**Subject:** CDS Review of LPF-20-00001 Big Creek Trails Final Plat – Request for additional information

CDS has reviewed the materials submitted for your final plat application LPF-20-00001 Big Creek Trails Division I for consistency with the conditions outlined in the associated preliminary approval documents for RZ-15-00001, see Ordinance (2016-24) and Resolution (2017-105).

BIG CREEK - DIVISION I
A PORTION OF THE N 1/2 OF THE SE 1/4 OF SECTION 29,
TOWNSHIP 20 NORTH, RANGE 14 EAST, W.M.
KITTITAS COUNTY, WASHINGTON

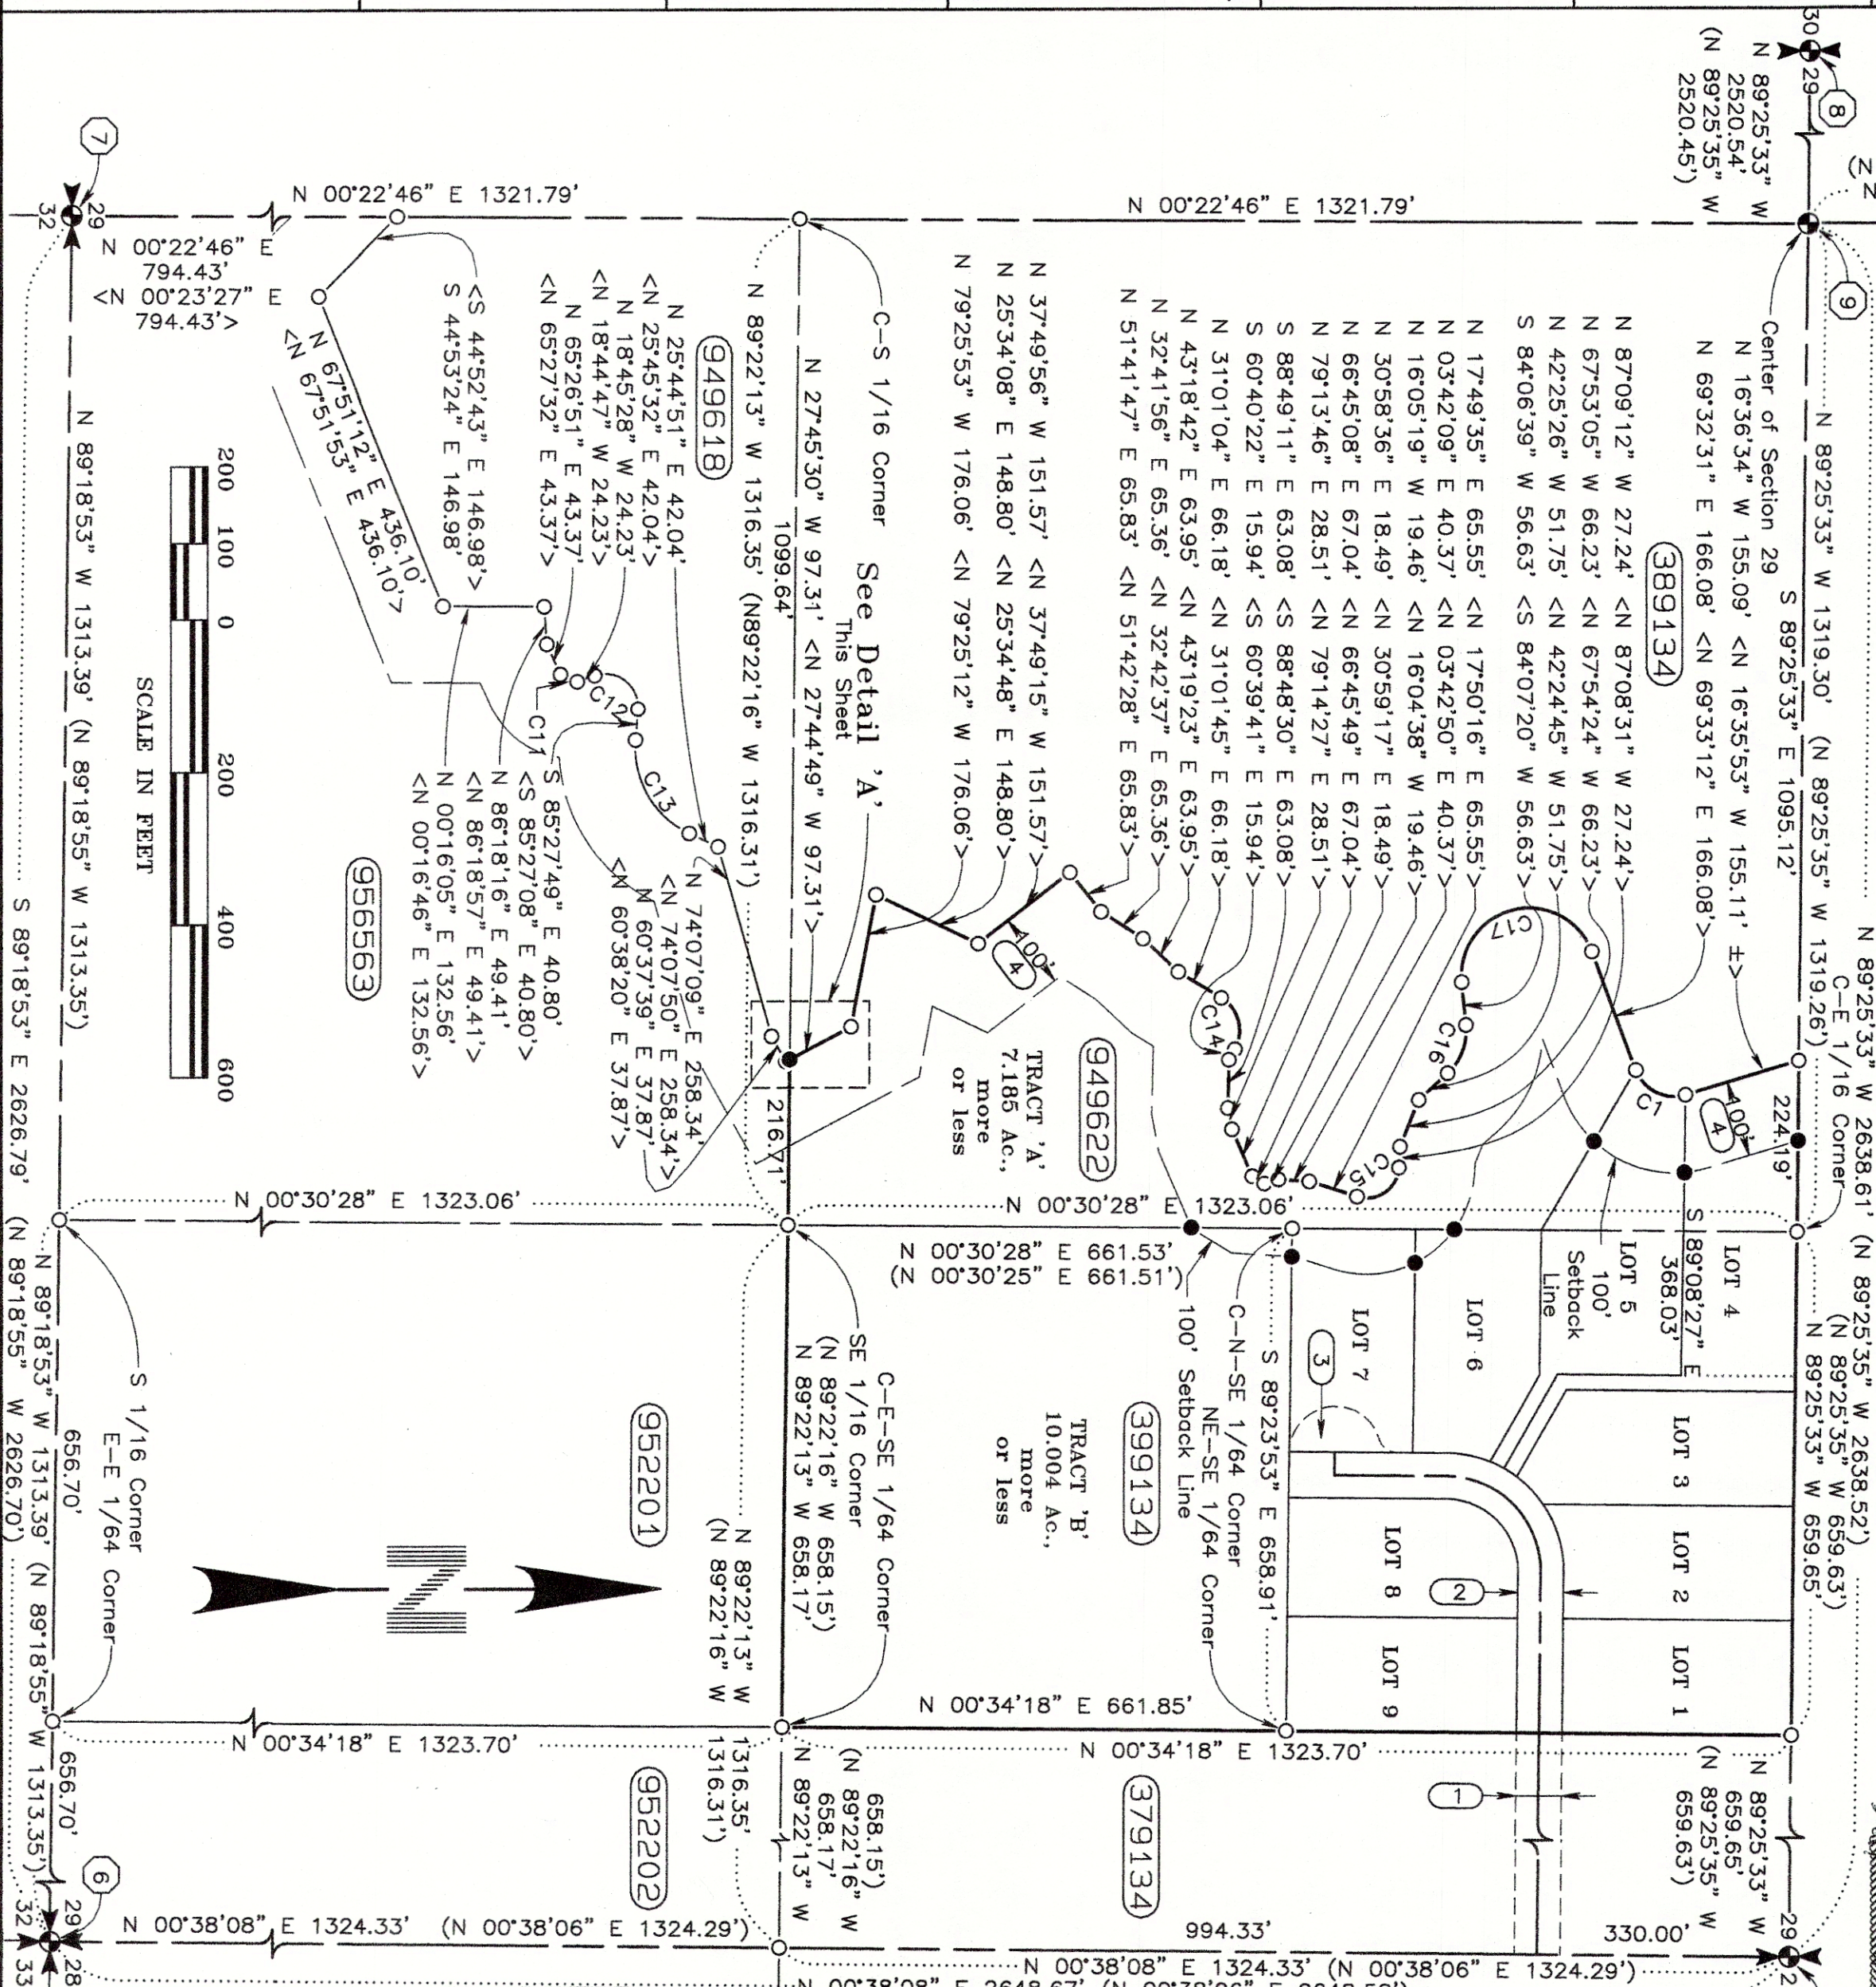
The survey submitted with your application demonstrates a 100-foot buffer/riparian corridor from the stream and appears to encroach upon proposed parcels 6 and 7. The condition requires a 200-foot buffer. The final survey will need to be updated to meet these conditions and a site plan will need to be provided demonstrating the location of the four required signs along the Big Creek Corridor that identify the area as a wildlife movement corridor.

The face of the final plat shall include the final plat file number LPF-20-00001

1. The final survey will need to be updated to demonstrate the 200-foot riparian and wildlife movement corridor, all wetlands, and critical areas. A site plan demonstrating the four required signs identifying the wildlife corridor will also need to be submitted
2. Photo evidence of the installed riparian and wildlife movement corridor signs
3. Proof of WDFW easements to maintain fish diversions and fish screens on Big Creek
4. The face of the plat shall include the final plat number LPF-20-00001
5. Submittal of a copy of the original landscape plan.
